Rezoning Transportation Analysis

Petition Number: 2023-172

General Location Identifier: 03113241

Date	Description
01-23-24	First Review (IW)
02-21-24	Second Review (KC)
03-26-24	Third Review (DR)

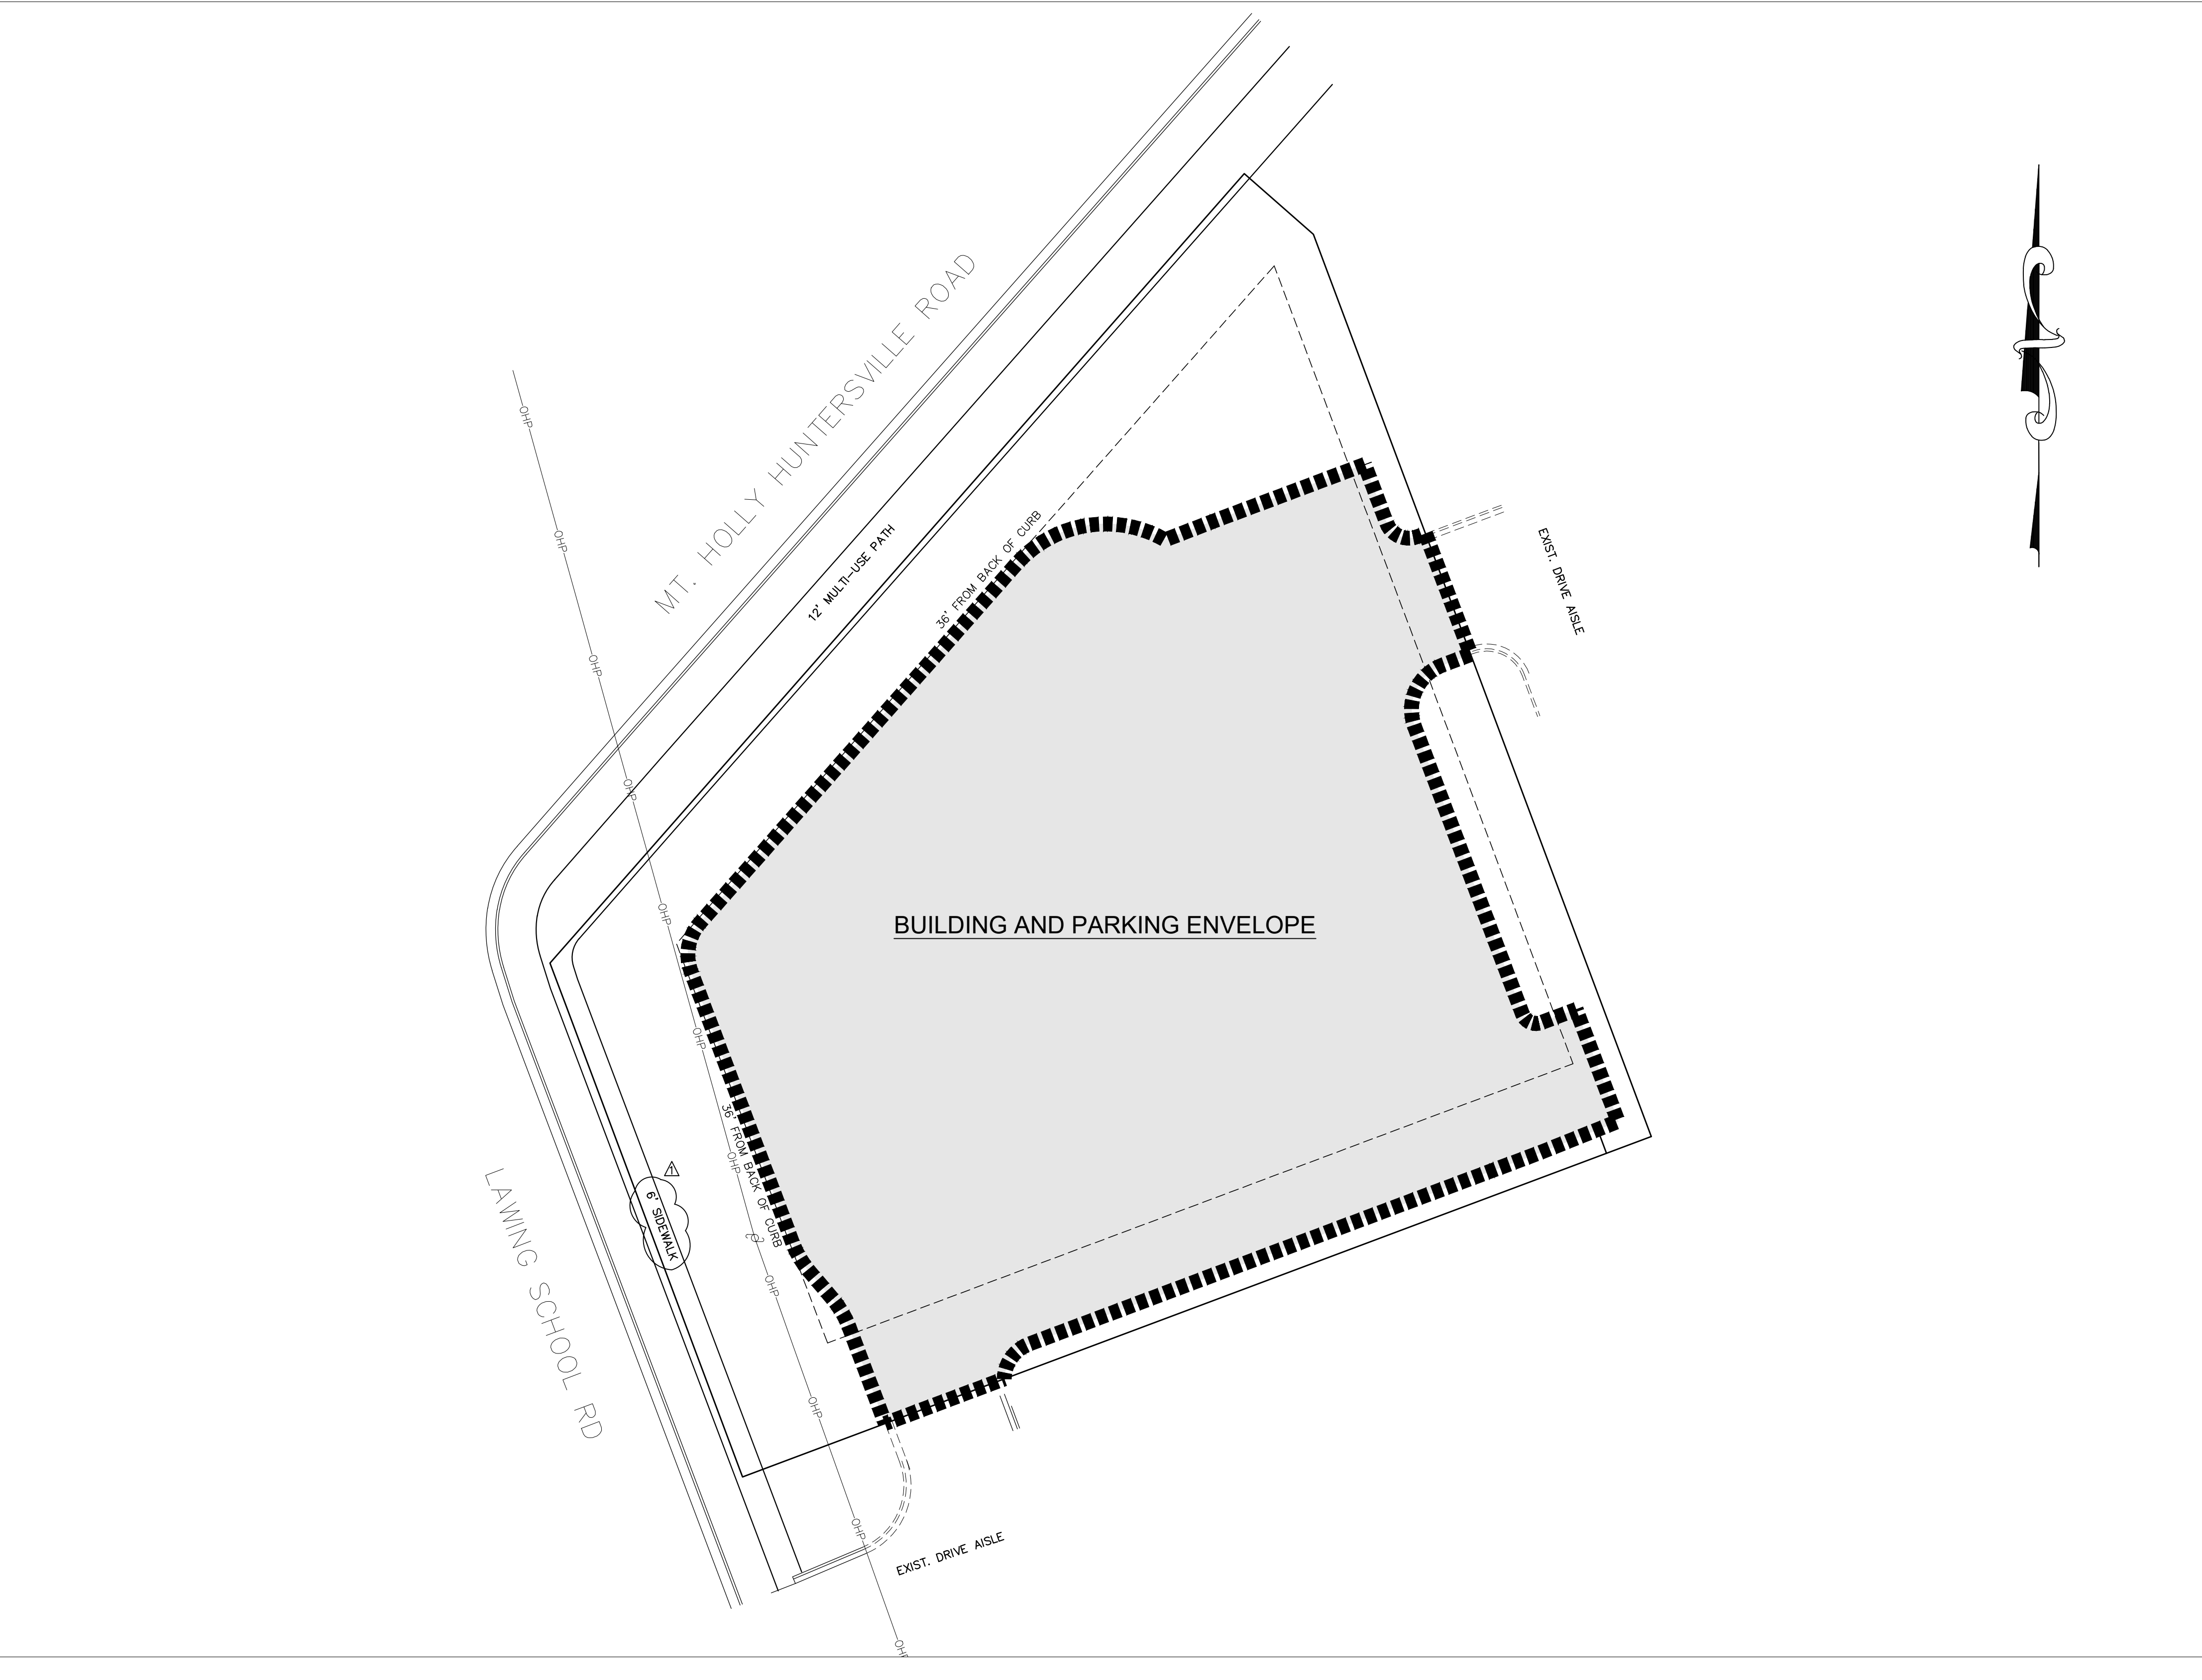
1. ~~Curblines:~~

a. ~~**Mt Holly Huntersville Road:** The future location of curb and gutter is 30' from centerline and appears to be in its existing location.~~

~~4+ Avenue, Shared Use Path per the Charlotte Streets Map~~

b. ~~**Lawing School Road (Spell it out):** The future location of curb and gutter is in its existing location.~~

~~CLDSM standard Local Collector Street U-07B~~

~~Label and dimension the curb and gutter from the centerline for each road on the site plan.~~

- ~~3. Revise site plan and conditional note(s) to commit to dedicate 50 feet of right-of-way from the Mt. Holly Huntersville road centerline. The site plan shall label and dimension the right of way from the road centerline.~~

- ~~4. Revise site plan and conditional note(s) to commit to dedicate 33.5 feet of right of way from the Lawing School road centerline. The site plan shall label and dimension the right of way from the road centerline.~~

- ~~6. Revise site plan and conditional note(s) to commit to cross access at south eastern portion of site along Lawing School Road to align with Article 31 in the UDO. It appears the site may be committing by layout on site plan. CDOT would like to see labeling and/or language stating this will specifically be set up for cross access.~~

~~7. Revise site plan and conditional note 5.c. to specify which sidewalk the site is committing to constructing. The site plan shows a 12' MUP but the note references the Local Collector Street, which is actually CLDSM U-07B not a local narrow street. The sidewalk would be required to be 8'. Please update and specify which sidewalk width the site plan will be committing to.~~

~~Comment Resolved 03-25-24: Density has been reduced.~~
